LSC TRANSPORTATION CONSULTANTS, INC.
545 East Pikes Peak Avenue, Suite 210
Colorado Springs, CO 80903
(719) 633-2868
FAX (719) 633-5430
E-mail: lsc@lsctrans.com
Website: <http://www.lsctrans.com>

MEMORANDUM

SUBJECT: Lorson Ranch East
(PUDSP-16-003) Review 2
Response to Comments Memorandum
LSC #164360

Following are the LSC Transportation Consultants, Inc. responses to the August 15, 2017 El Paso County Planning and Community Department comments letter regarding the July 12, 2017 Updated Traffic Impact and Access Analysis by LSC.

Figure 3

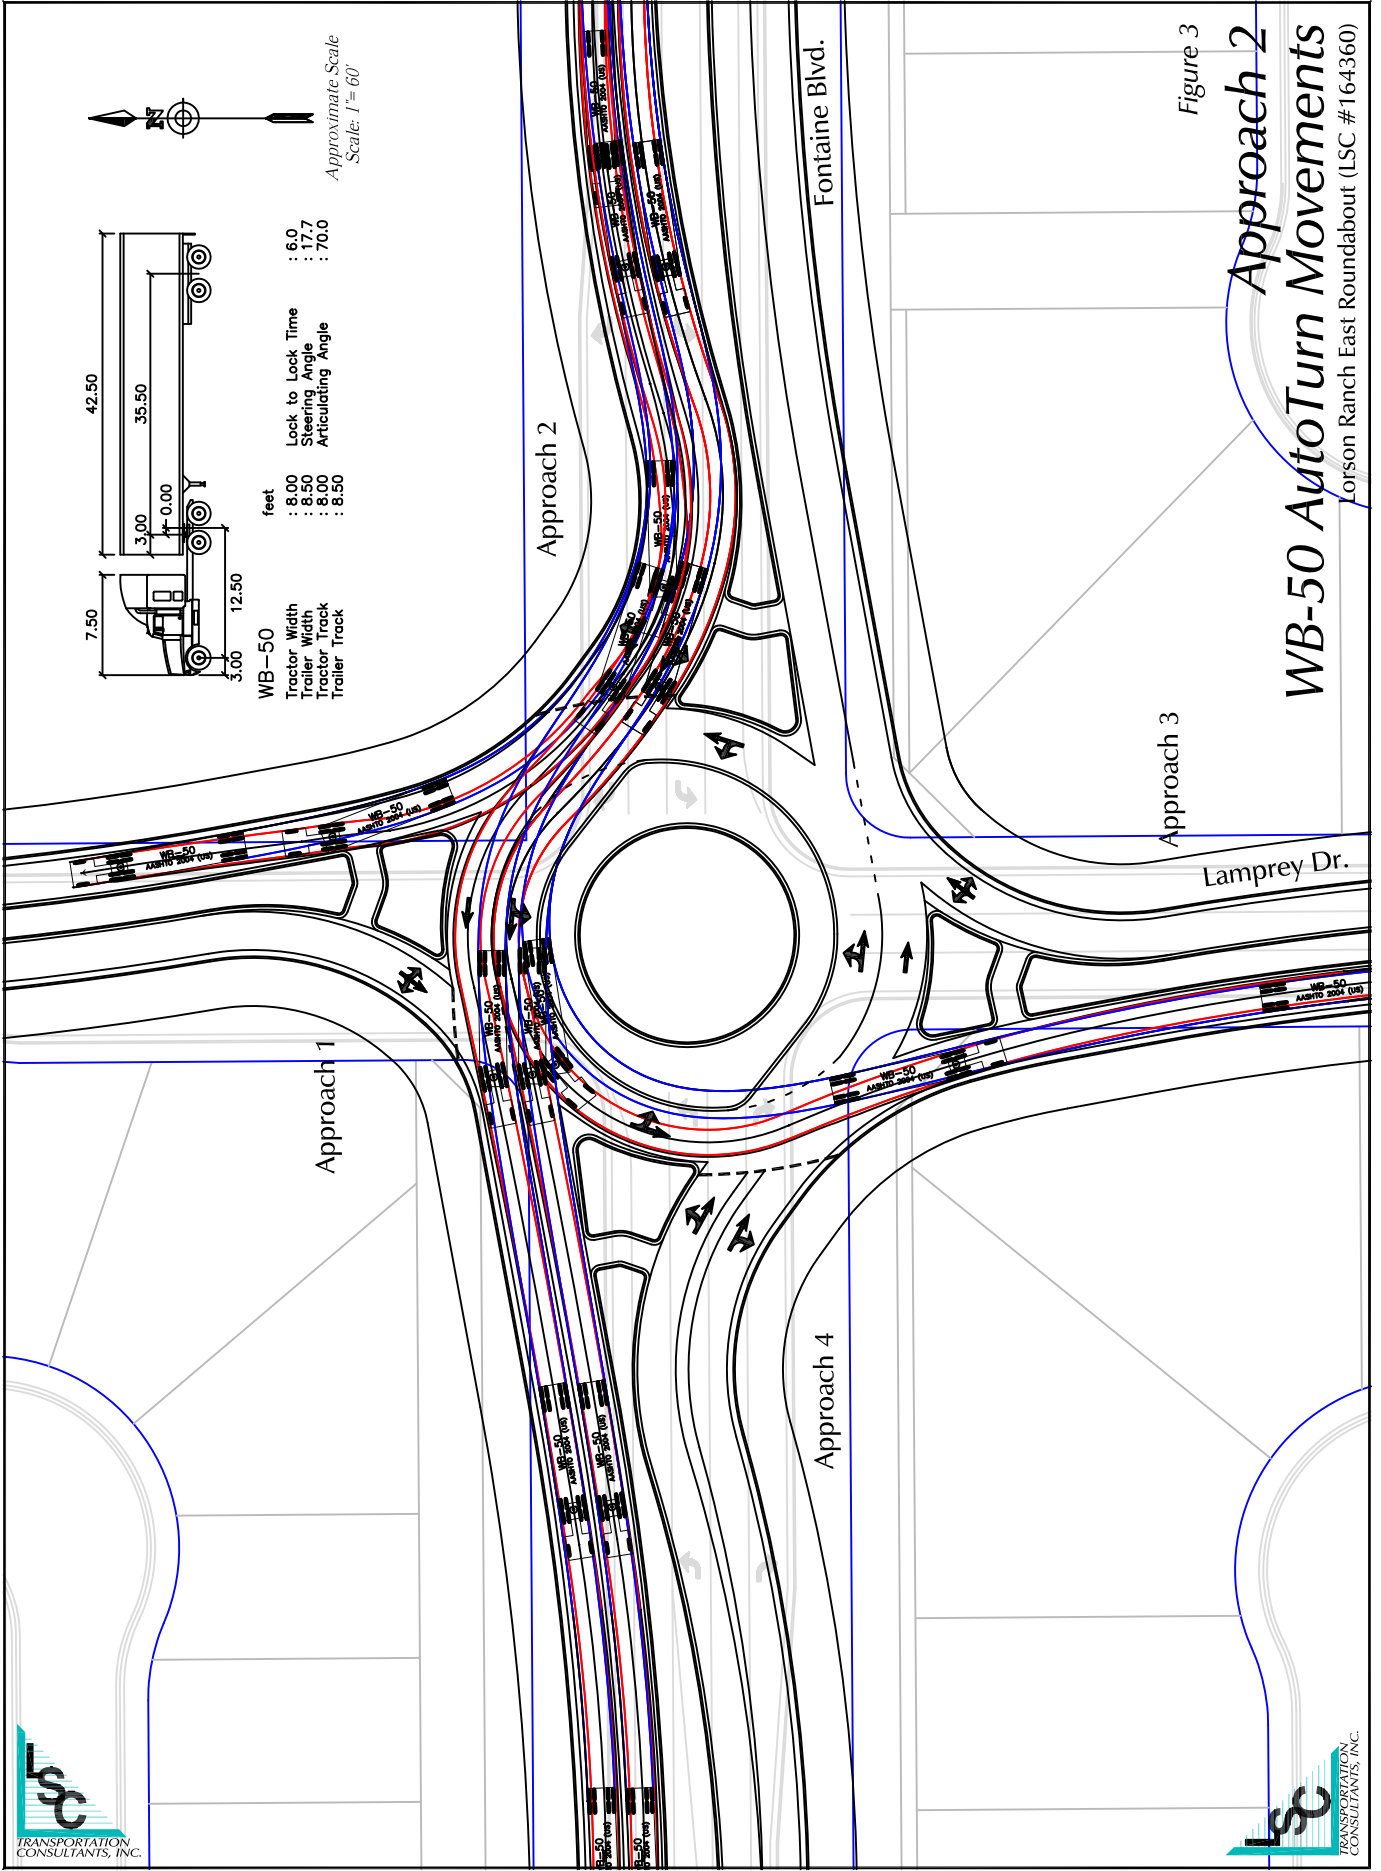
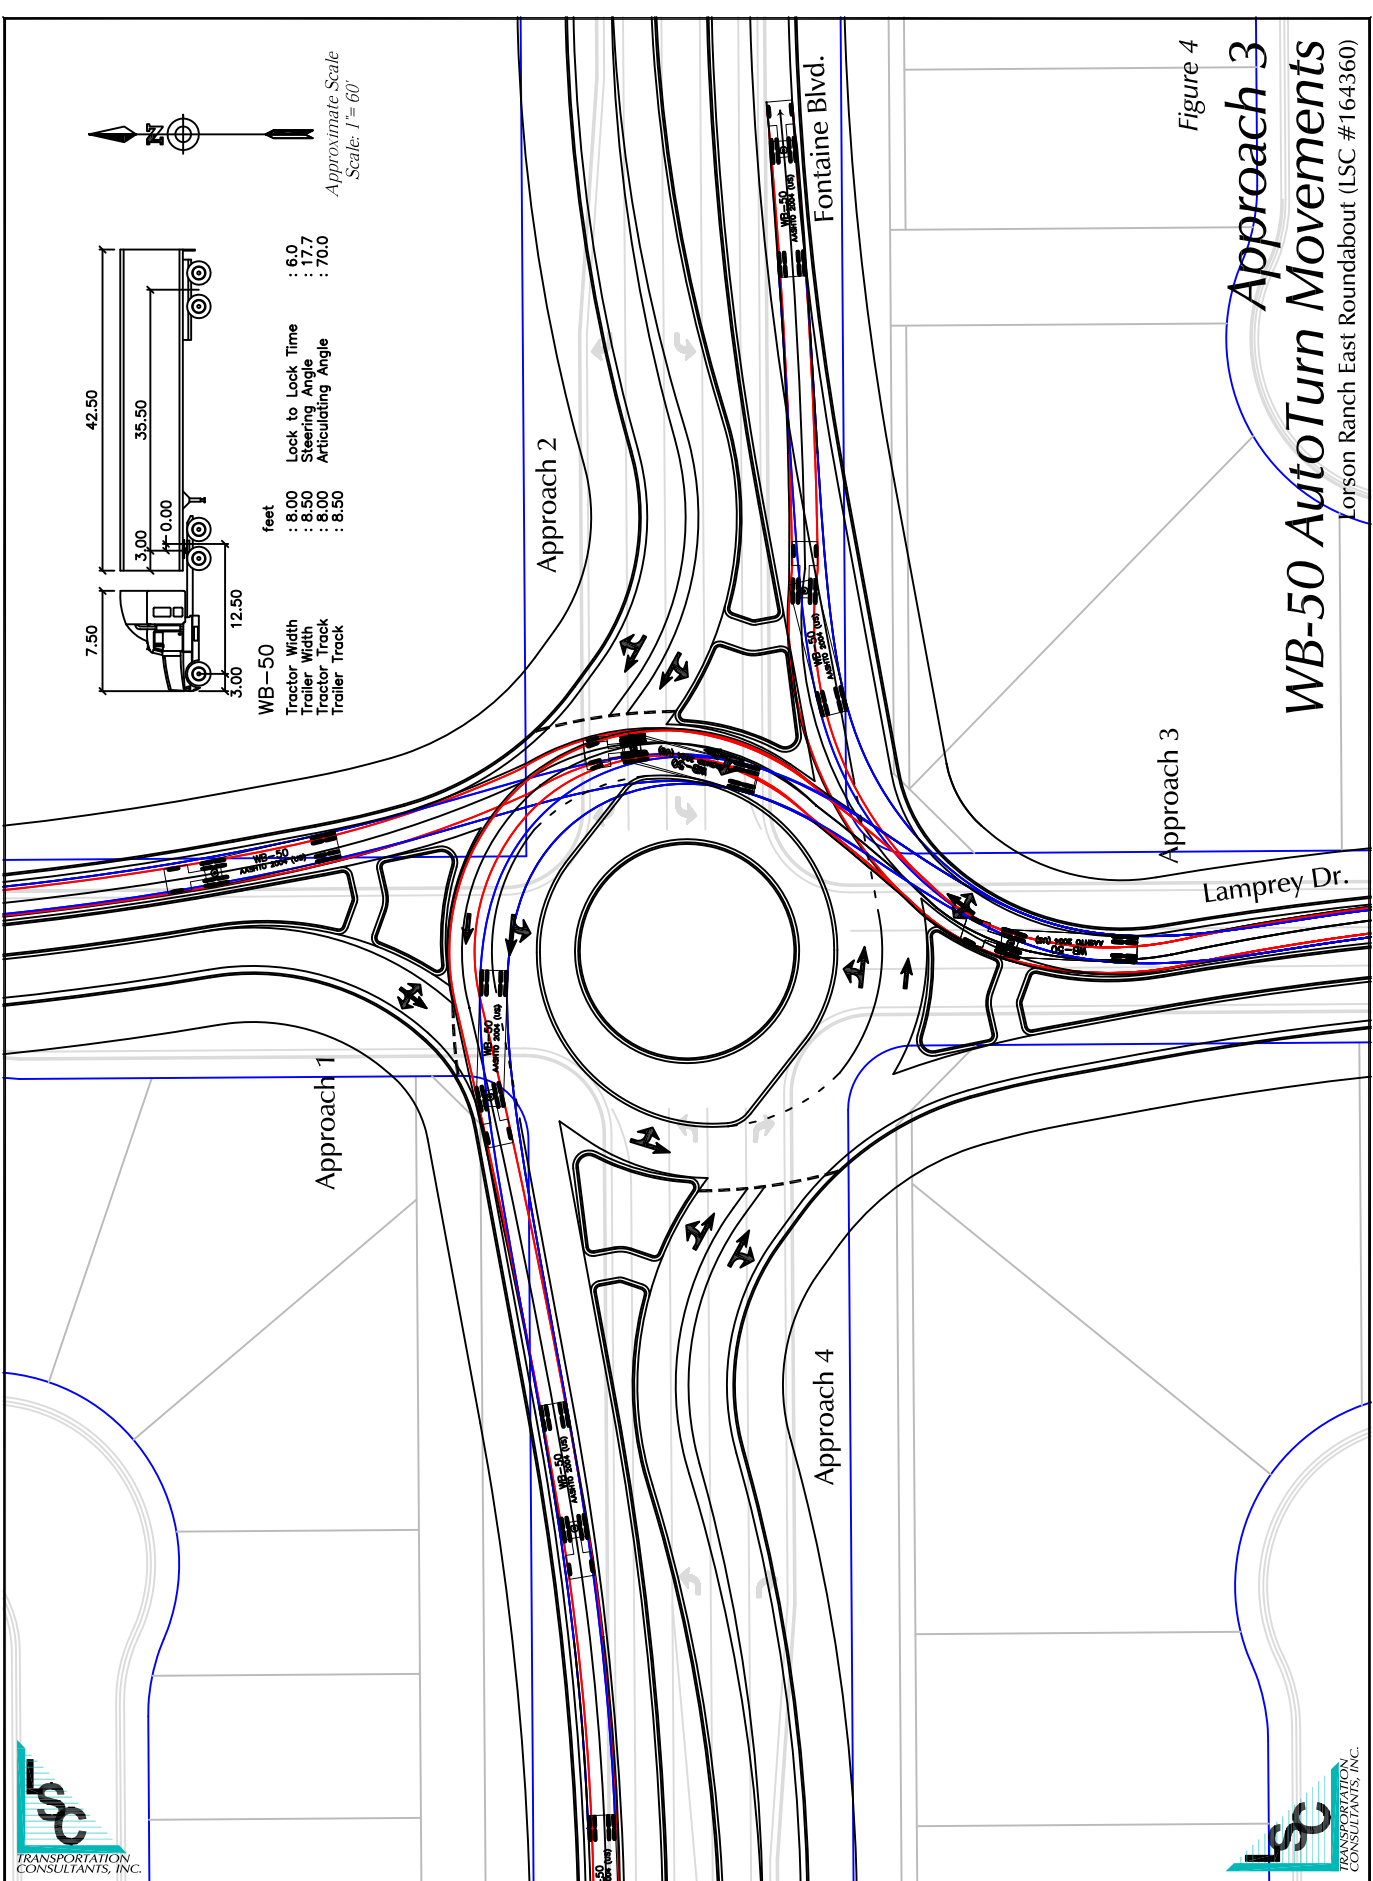
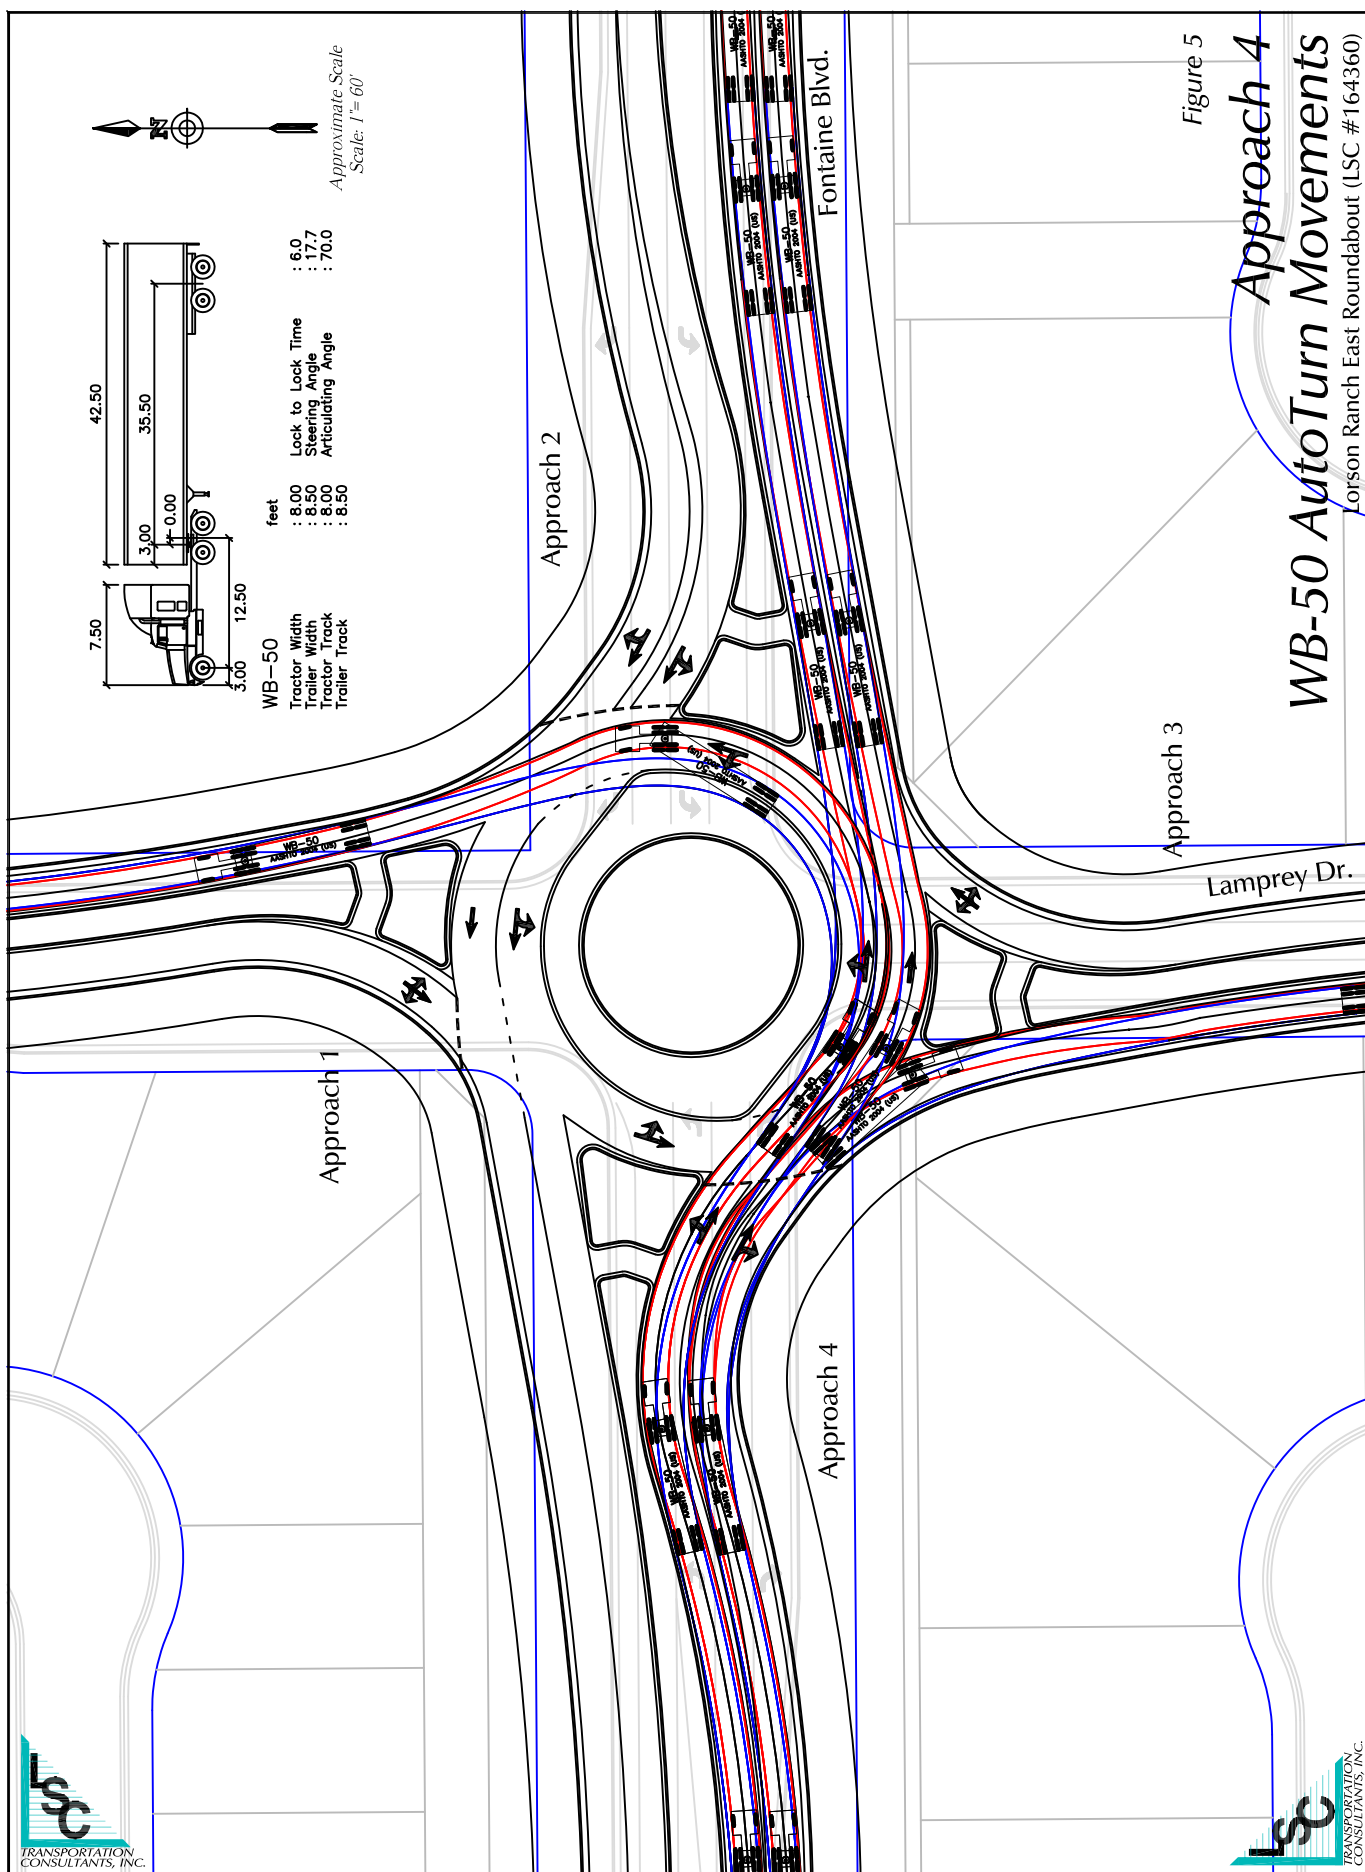
8. *Regarding the e-mailed comments dated March 17, 2017:*
*a. **It needs to be clearly documented that the roundabout is the proposed intersection at Lamprey/Fontaine. If the roundabout is the chosen option, could it not be designed to be expandable to 2-lanes when necessary along with widening of Fontaine Blvd.?***

LSC Response: The updated TIS clarifies this and clearly presents the roundabout as the proposed solution. The report also includes a roundabout design report and exhibits with the design of a future two-lane roundabout.
